STATE OF NORTH CAROLINA  
DEPARTMENT OF TRANSPORTATION

October 26, 2004

**Subject: Supplemental Information for Permit Modification Application to Section 404 and Section 401 permits and Neuse Buffer Certificate** for the Northern Wake Expressway (I-540) from US 1 to US 64 in Wake County, Division 5. State Project No. 8.2401701, Federal Aid Project No. F-123-1(1), **TIP No. R-2000 F&G**; State Project No. 8.2401701, WBS Element No. 34365.1.1. NCDENR-DWQ Water Quality Certification Project No. 030114 and USACE Action ID 199920387.

**Change to Lateral Base Ditch**

SHEET **39b** OF **50** 7/3/03

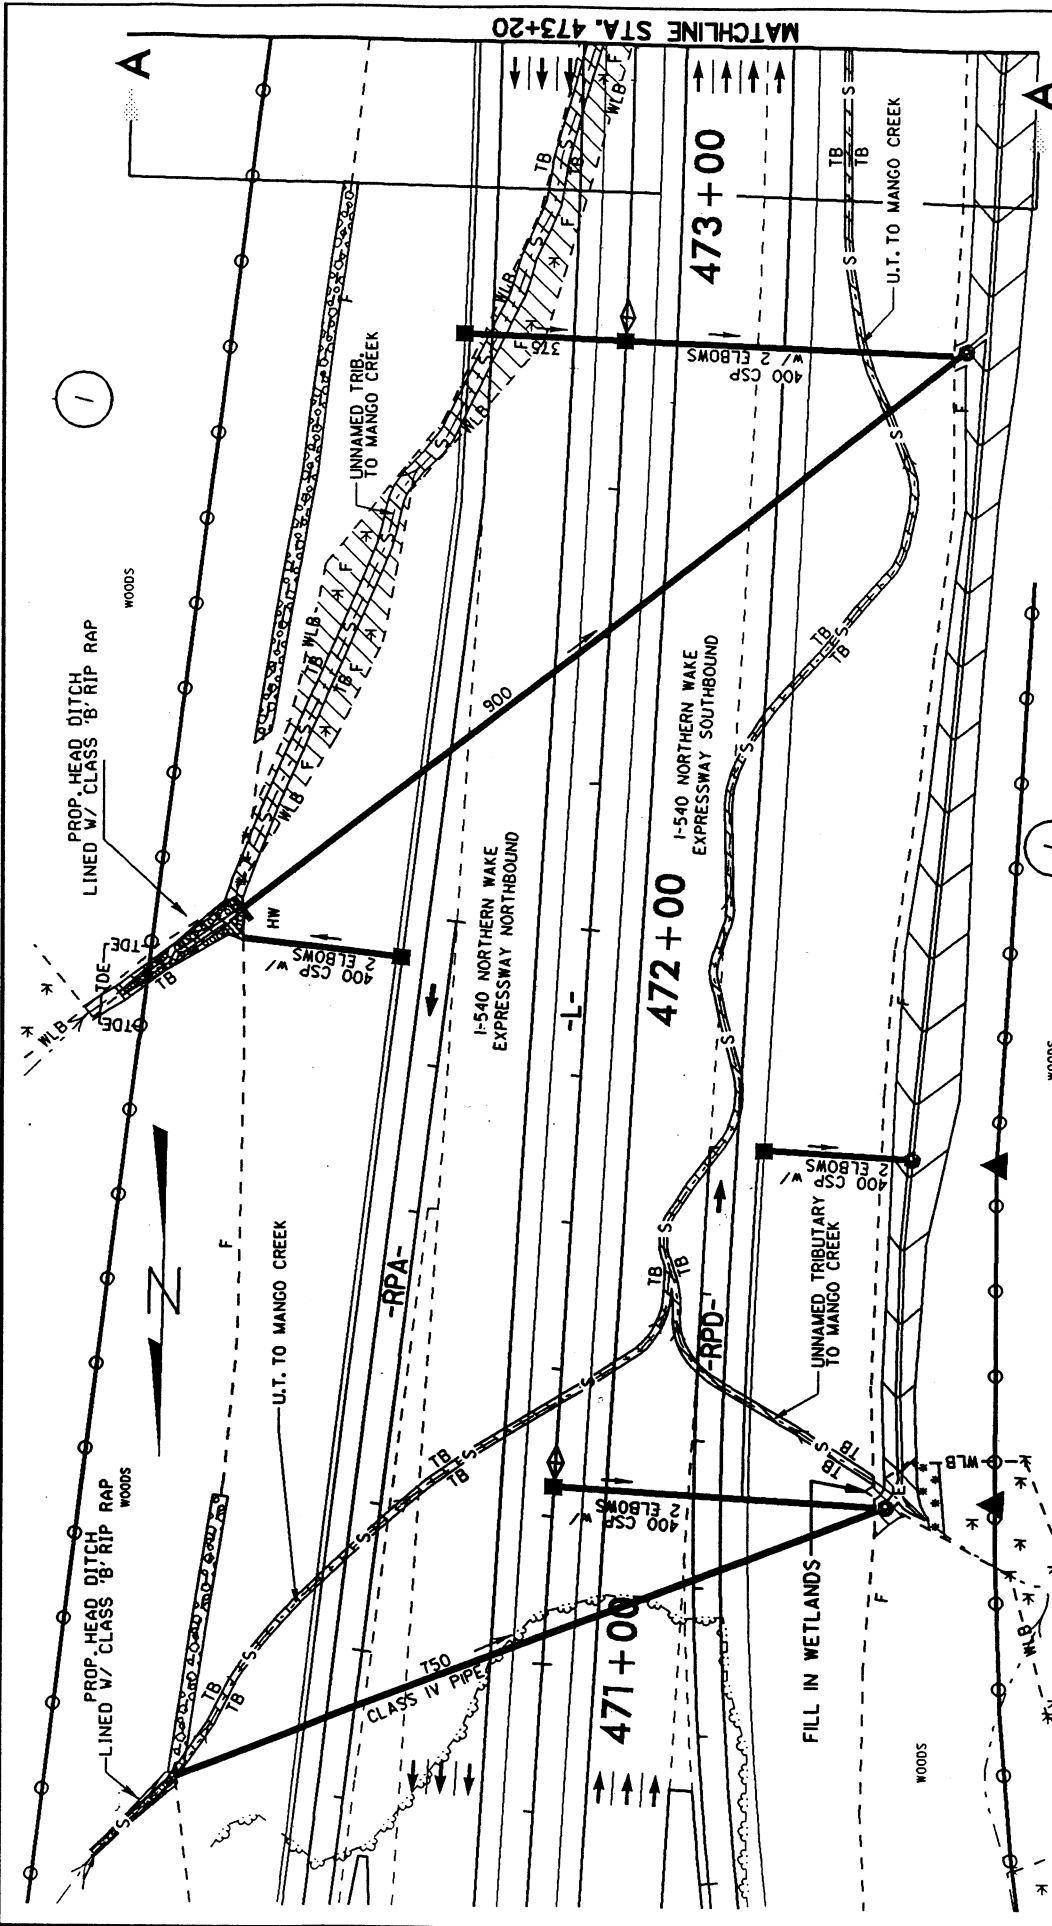
The lateral base ditch at this site was constructed to the current plans but during construction it was found to be unstable. The velocities in the current base ditch design exceed the stability limit and that it should have been lined. To stabilize the proposed 0.6m lateral base ditch reflected on plan sheets 17 and 18 (Detail "UU") is to increase the base width to 0.9m (3.0 feet) (2 ft more than current design), hold or maintain the constructed 2:1 front ditch slope, adjust the proposed ditch back slope to 3:1, and line the entire length specified in detail "UU" with permanent soil reinforcement matting (PSRM) to a height of 0.6m (2.0 feet, minimum depth specified in Detail "UU") on the slopes. The construction plans and permit drawings are revised.

NOTE: LATERAL BASE DITCH RIGHT OF  
 -L- TO BE LINED WITH PERMANENT  
 SOIL REINFORCEMENT MATTING (PSRM)
